Your Ref :
Our Ref : WA/61/14/NMA

Application for a non- material amendment following the grant of WA/71/12/ to duplicate small window on Eastern elevation.
1 Holly Tree Grove, Walberton, ,

Client	Hanbury Properties Ltd				
Job title	Land at The Holly Tree PH				
	Walberton				
	West Sussex				
Drawing title	House 1				
	:-:-				
	Plans & Elevations				
Drawn	Date	Checked	Date	Scale	At
C.P.	23/08/12	N.H.I.	25/01/12	1:100	
Job N°	Drawing N°		Rev.		
12-083	P104		C		
status	IA

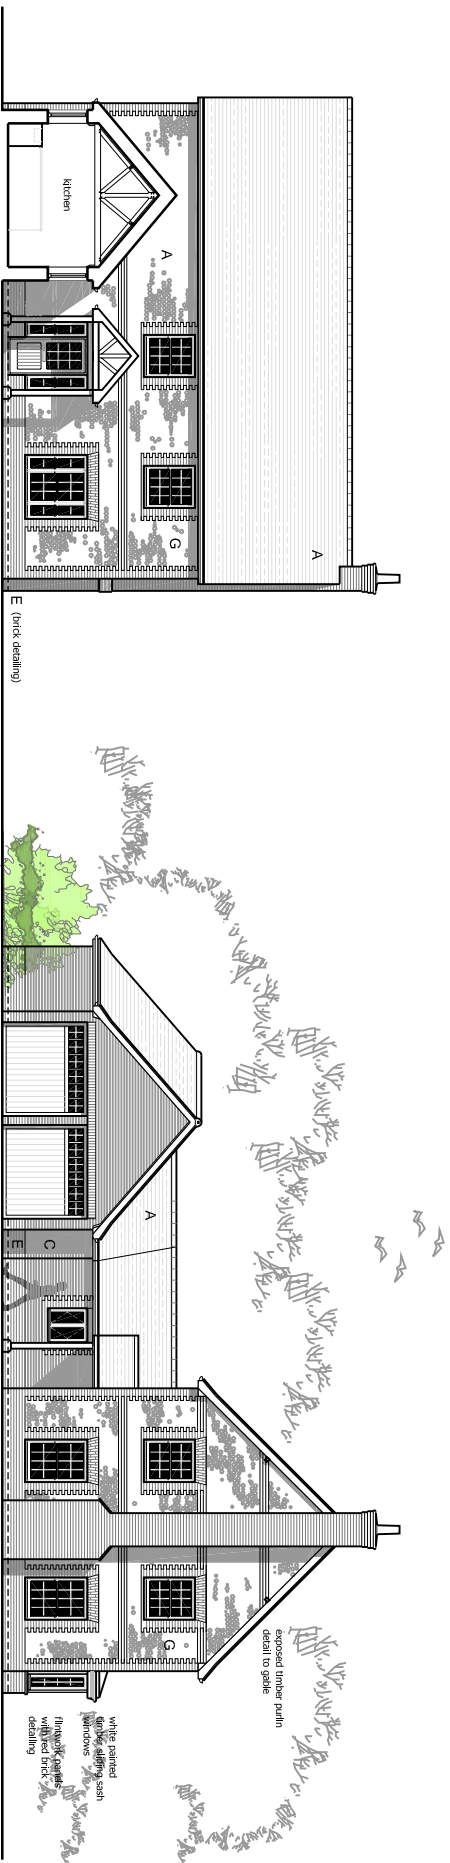
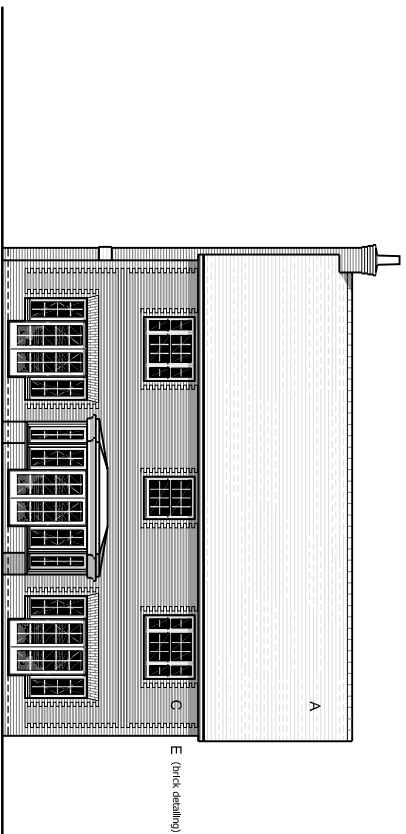
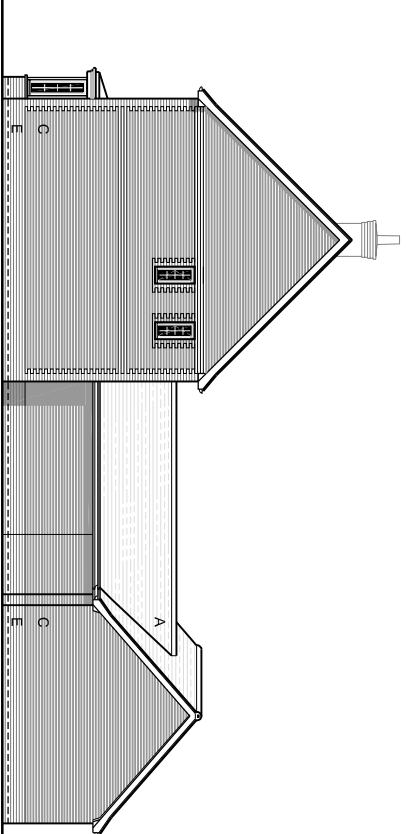
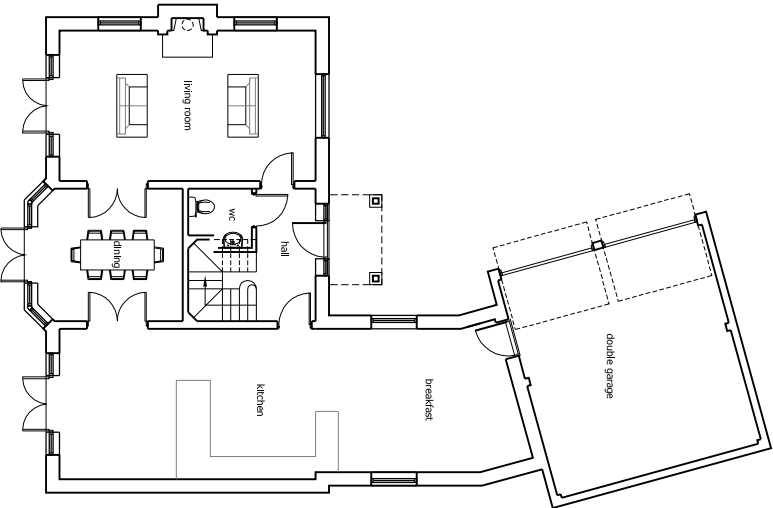
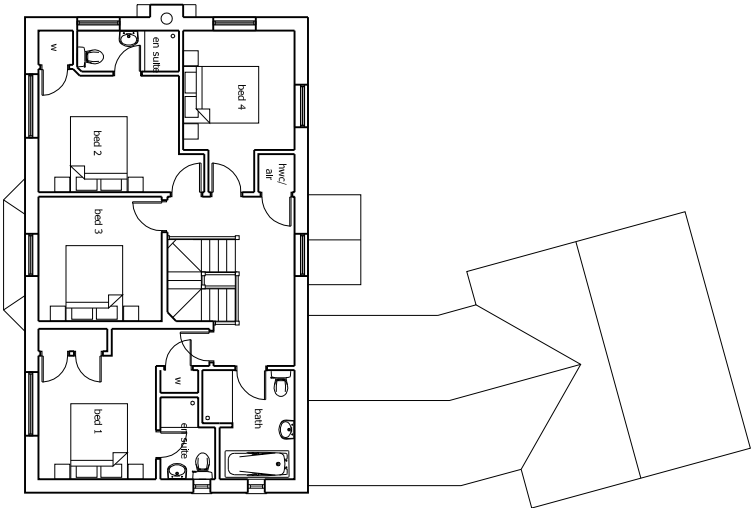
I refer to your recent application for a Non Material Minor Amendment. From the information submitted I am able to take the alterations proposed namely to add an additional window at first floor level on the east elevation of House 1 as a Non Material Amendment to WA/71/12. Accordingly, drawing number PL04C has become the approved elevation and floor plan for planning permission WA/71/12 in relation to plot 1.
